**From:** Martyn White **On Behalf Of** Conservation Officer  
**Sent:** 30 November 2018 09:50  
**To:** Planning.Responses  
**Subject:** AB/114/18/CLP

**AB/114/18/CLP**

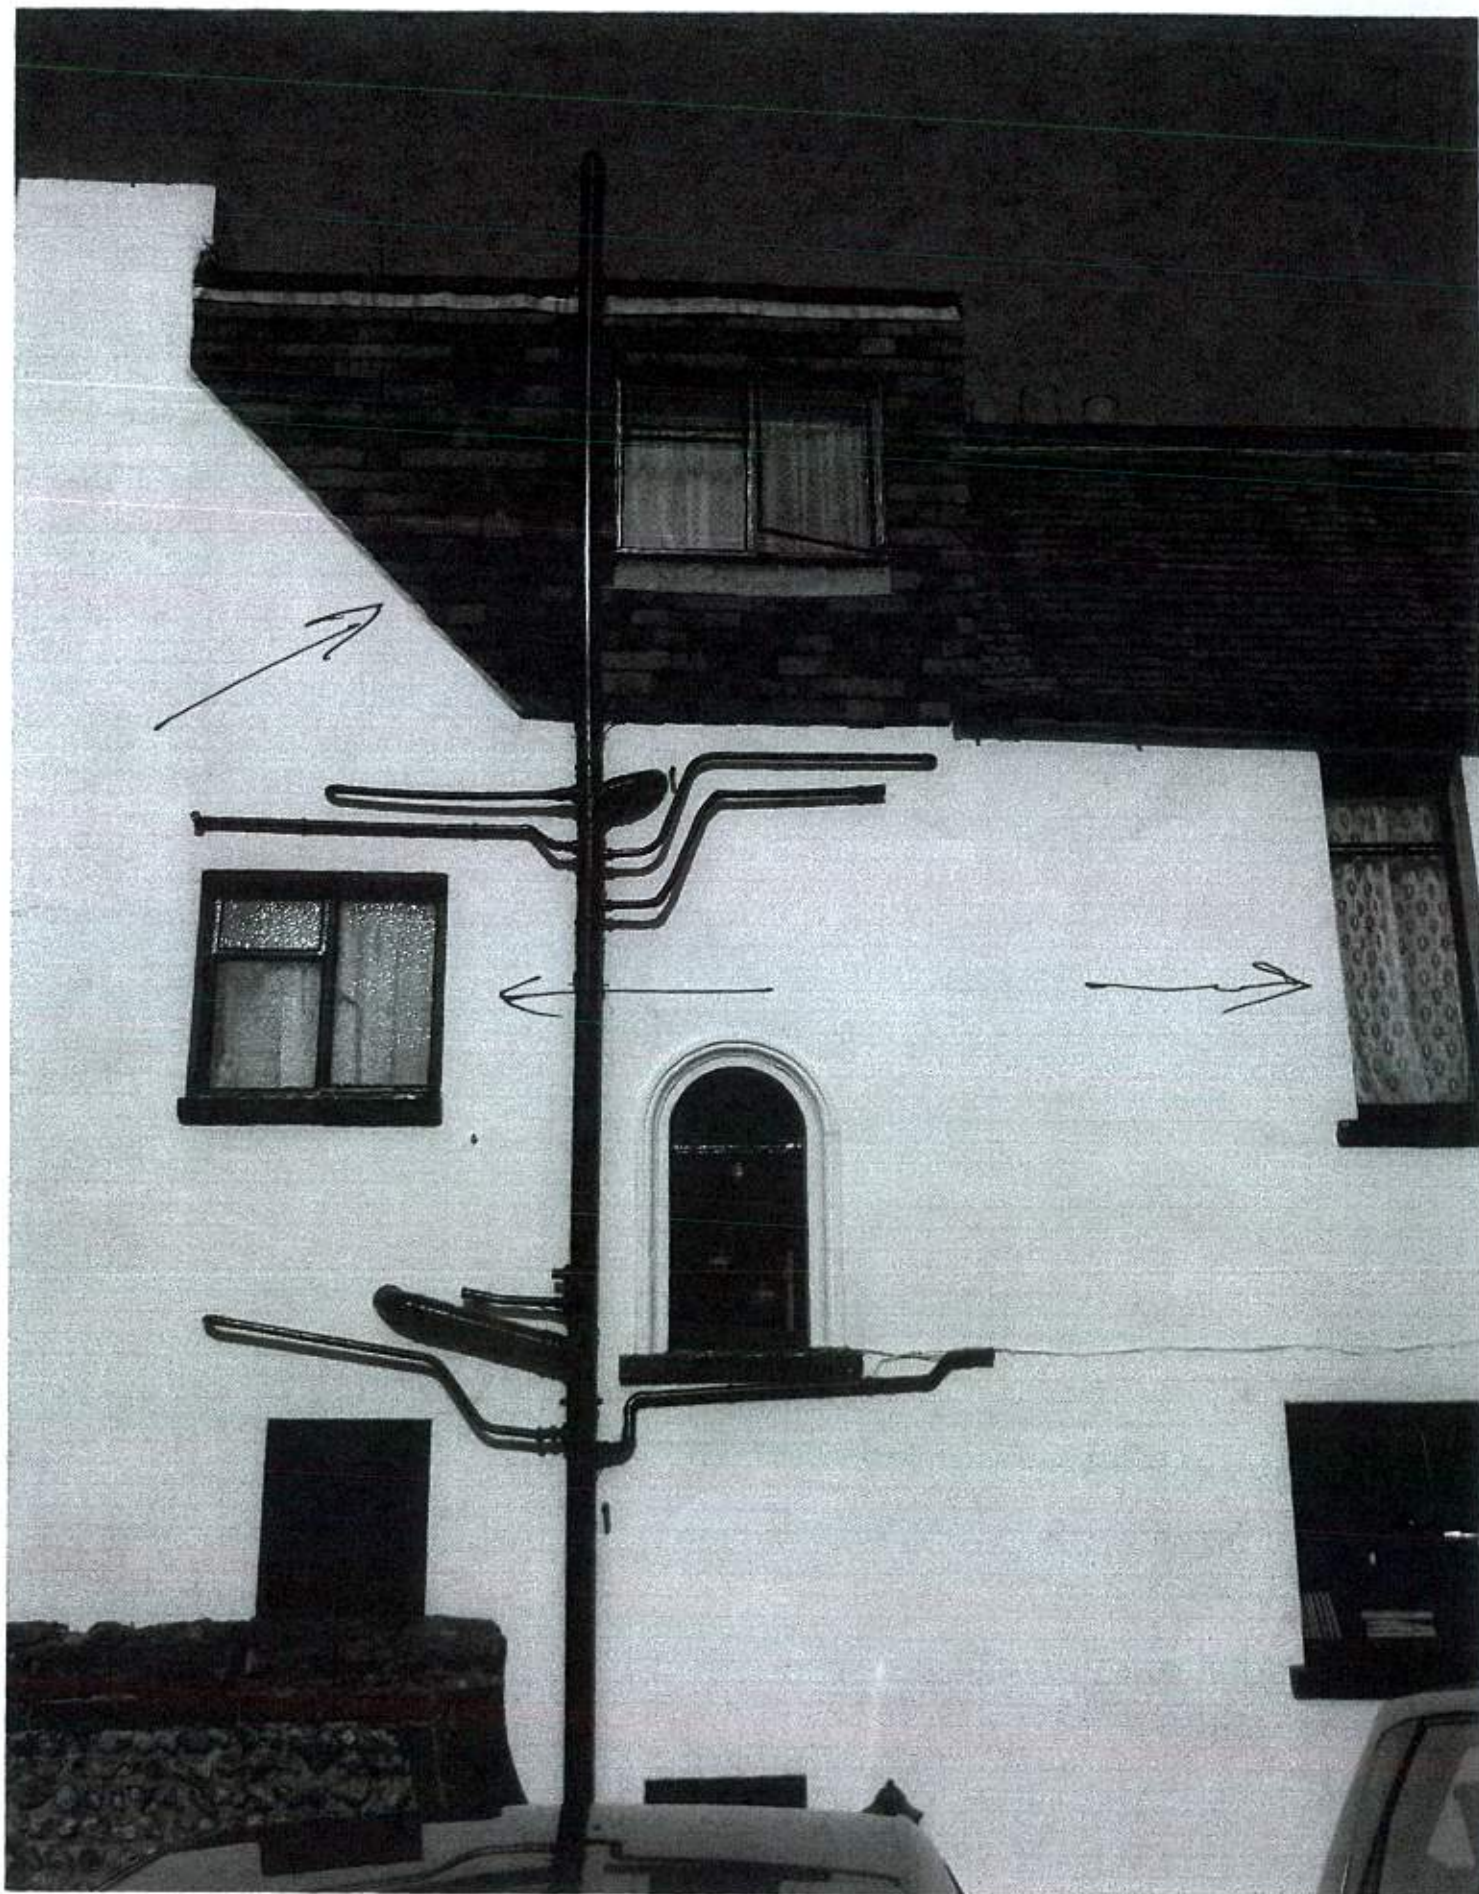
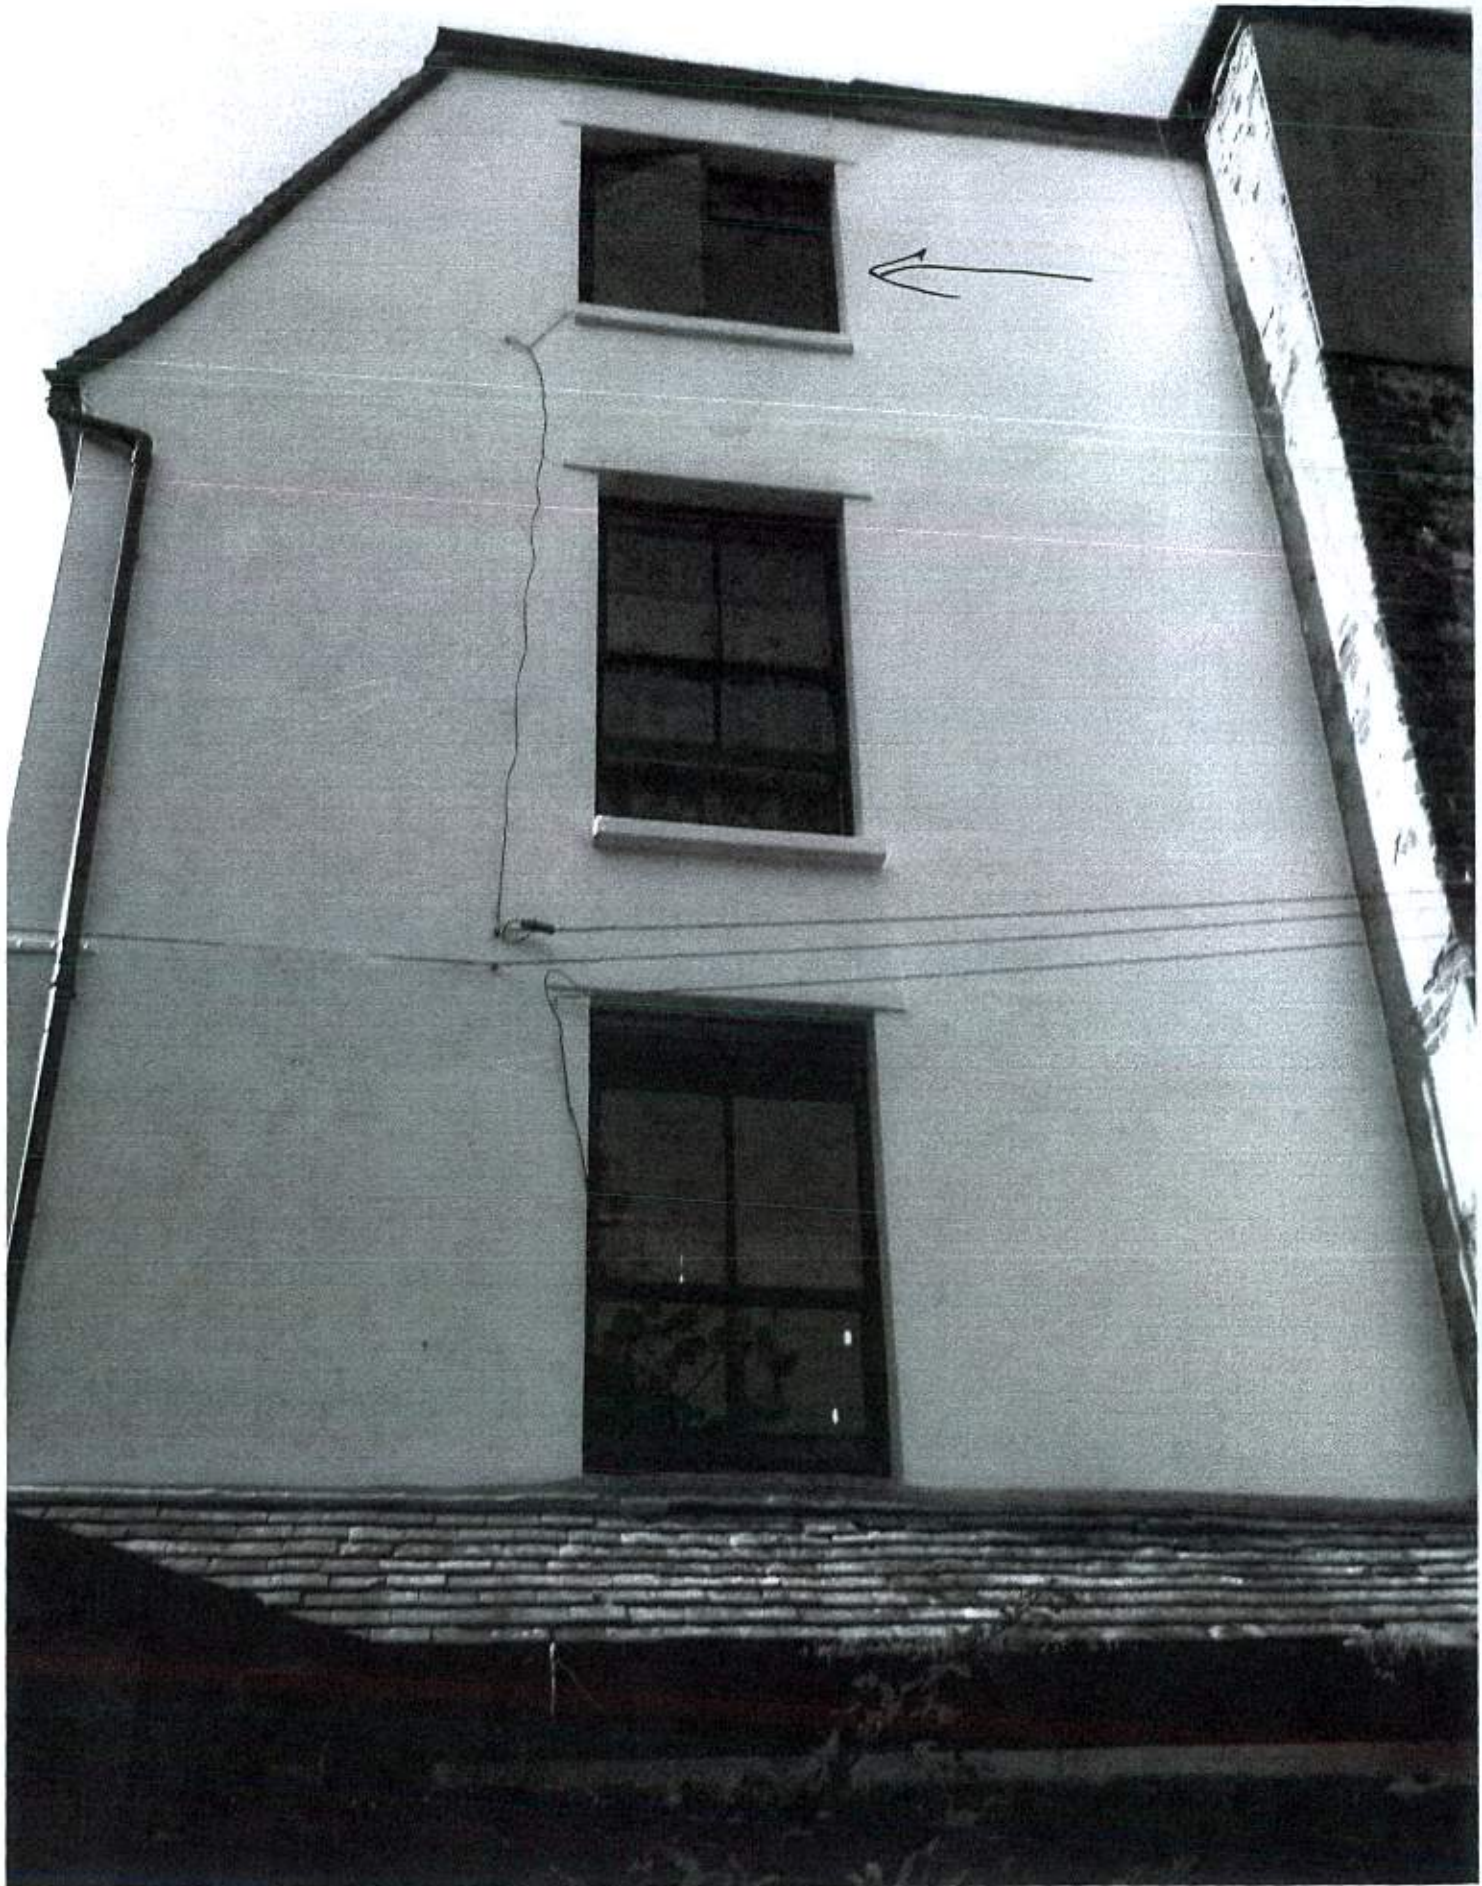
The application relates to a number of casement windows to the side and rear of the property. The existing windows appear to be crittal, or similar, painted back. The materials used, along with the profile of the existing windows means that they do not dominate the appearance of the elevation (despite their dark colour).

The location of the windows on the side elevation means that they are visible from the public realm, and therefore the proposed replacement windows have the potential to affect the character of the building.

I note that the intention is that the material changes from metal to UPVC, but that the intention is to maintain the existing opening arrangement of the replacement windows. However, from a conservation perspective the design, detailing and operation of the proposed windows can make them appear different to traditional windows. Further, the visual effect of shiny modern plastic is out of keeping with more traditional materials. It is considered that something similar to the existing would be supported.
